TRANSMITTAL SHEET

<p>To: City of Mercer Island</p> <hr/> <p>Company: Department Services – Building & Planning</p> <hr/> <p>Address: 9611 SE 36 Street Mercer Island, WA 98040</p> <hr/>	<p>From: Erik Voris</p> <hr/> <p>Project: Project 2109-226</p> <hr/> <p>Date: 2/28/2022</p> <hr/> <p>Regarding: Correction Cycle#1</p> <hr/>
--	--

Planning Review Corrections received on 12/22/21 from Tim McHarg

A0.2

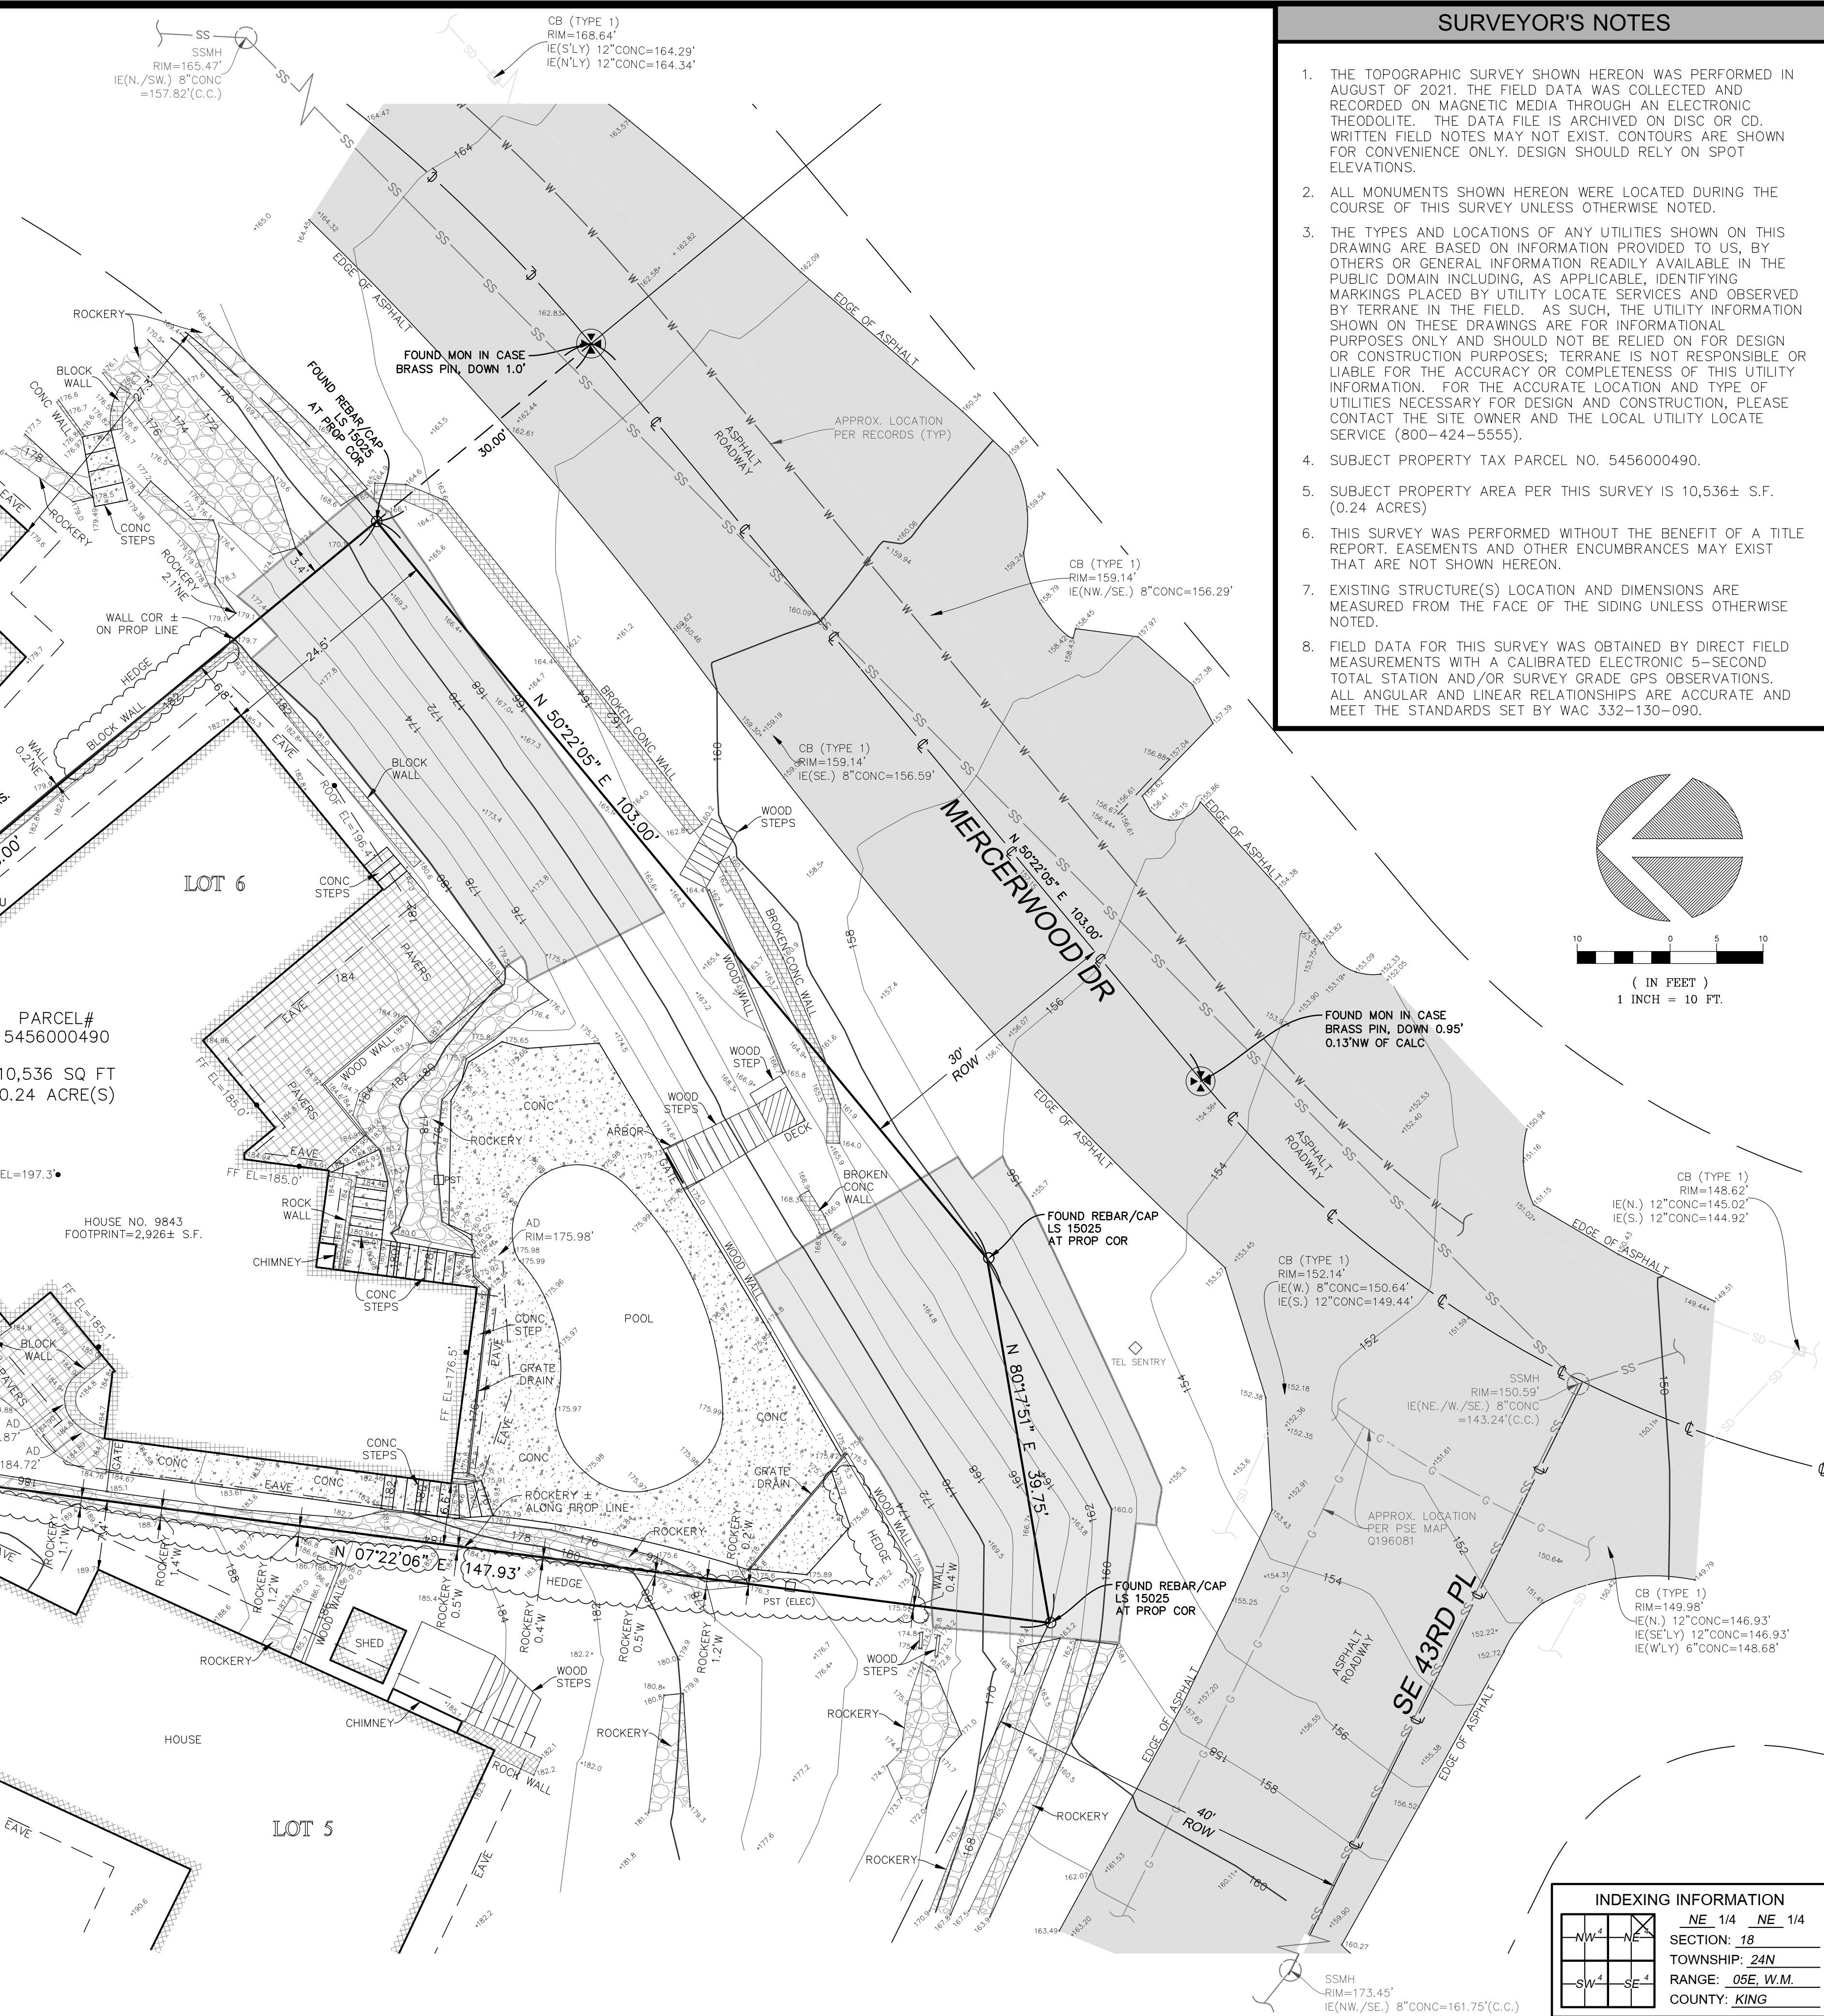
1. Lot slope is 16.3%. Please correct for clarity.
2. Please confirm that existing rockeries have been included in the "retaining wall" line item in the hardscape calculations. If not, please add them as a separate line item.
3. Please provide Average Building Elevations on this sheet or on Sheet A1.1.
4. Please clarify surfacing after pool/patio demo to confirm it is not hardscape.
5. Please provide seating wall height. Per 19.02.020.C.3.g, all portions of the seating wall in the rear yard setback must be 30" or less.
6. Per MICC 19.02.020.C.3.a.ii, no building elements are permitted to encroach into minimum side yard setbacks. Since this is part of the foundation, it is a building element. The existing foundation wall will need to be cut down to match proposed grade.
7. Please correct to West Elevation.

- 1 - The lot slope has been revised on sheet A0.2.**
- 2 - The portions of existing rockery along the west lot line have been shown on A1.1 site plan and added to site plan A0.2 Lot Coverage Calculations as a separate line item. A revised site development worksheet has been included with the correction response documents.**

- 3 - The average building elevations and wall lengths are shown on 1/A0.2 Site Plan – Lot Width & Average Grade Diagram. The average grade calculation is located on A0.1 under the Maximum Structure Height within the Land Use Code Review Section. The average grade calculation has been added under 1/A0.2.**

A2.2

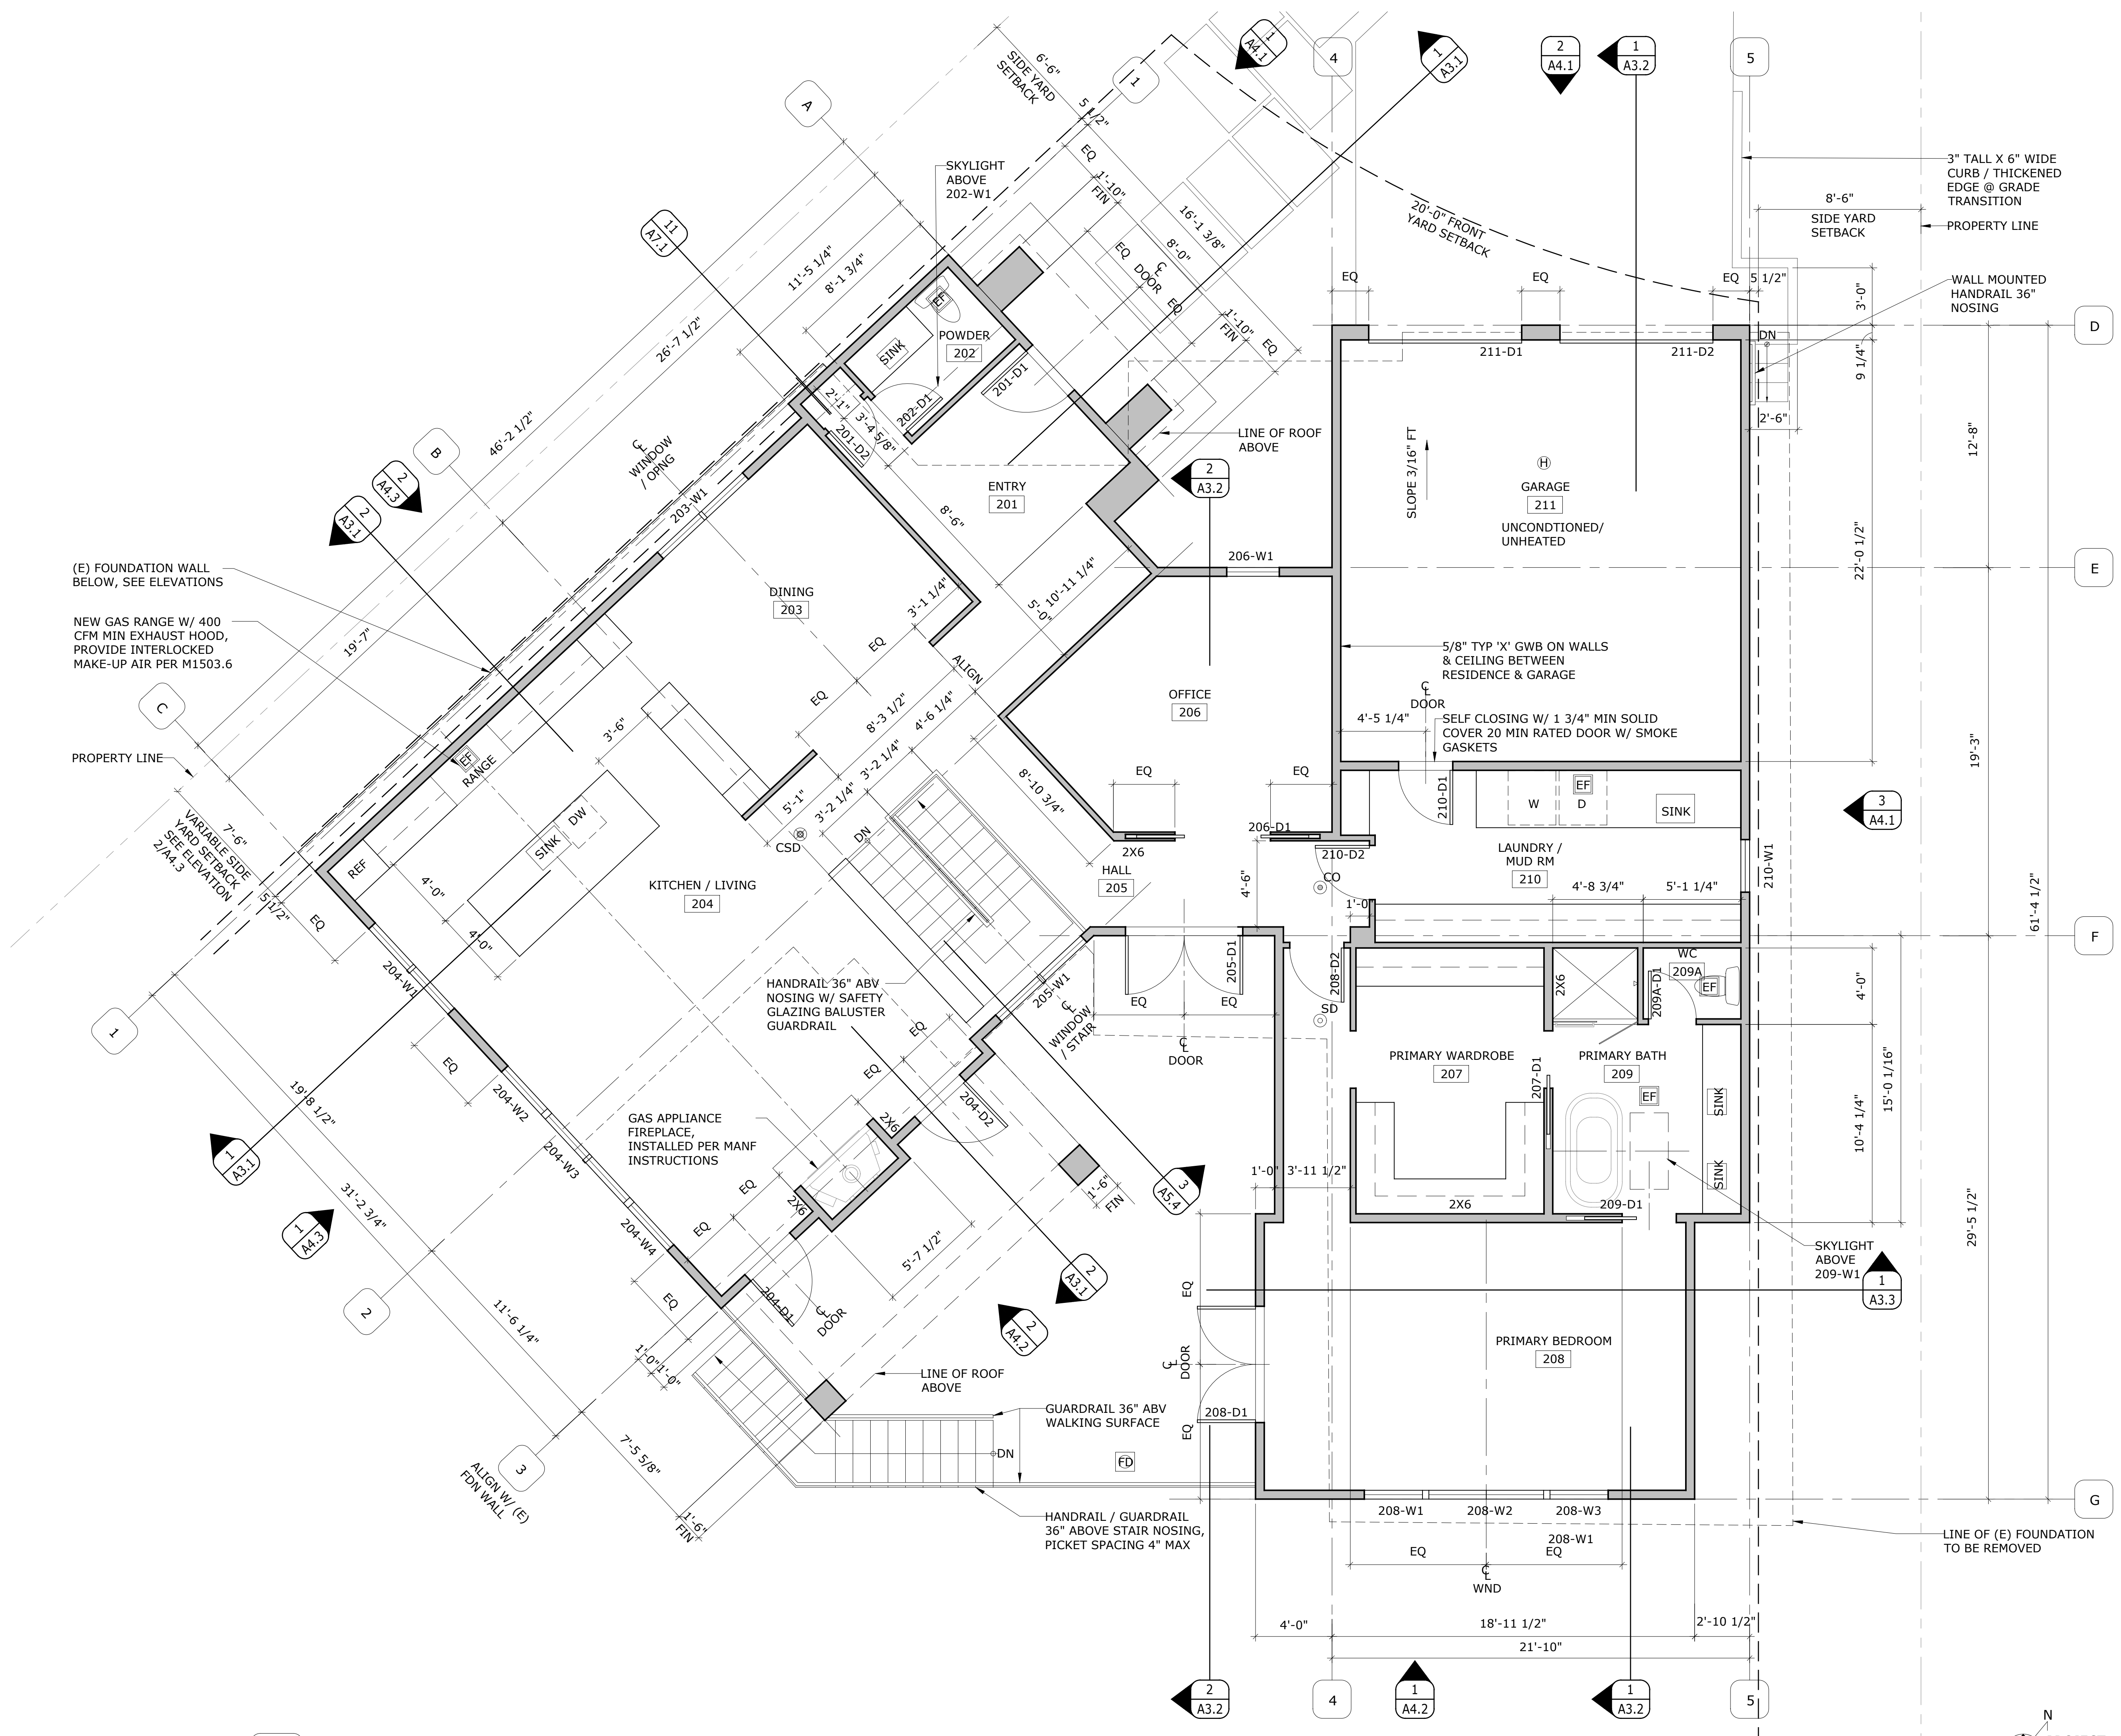
4. The carbon monoxide alarm outside the Primary Bedroom should be revised to a combination smoke/carbon monoxide alarm. See Sheet A2.2 and IRC R314.4.3.

- 4 - The carbon monoxide detector outside the Primary bedroom has been revised to a combination smoke / carbon monoxide detector.**
- 4 - SD detectors has been shown in bedrooms on A2.1 Lower Floor Plan and A2.2 Main Floor Plan.**
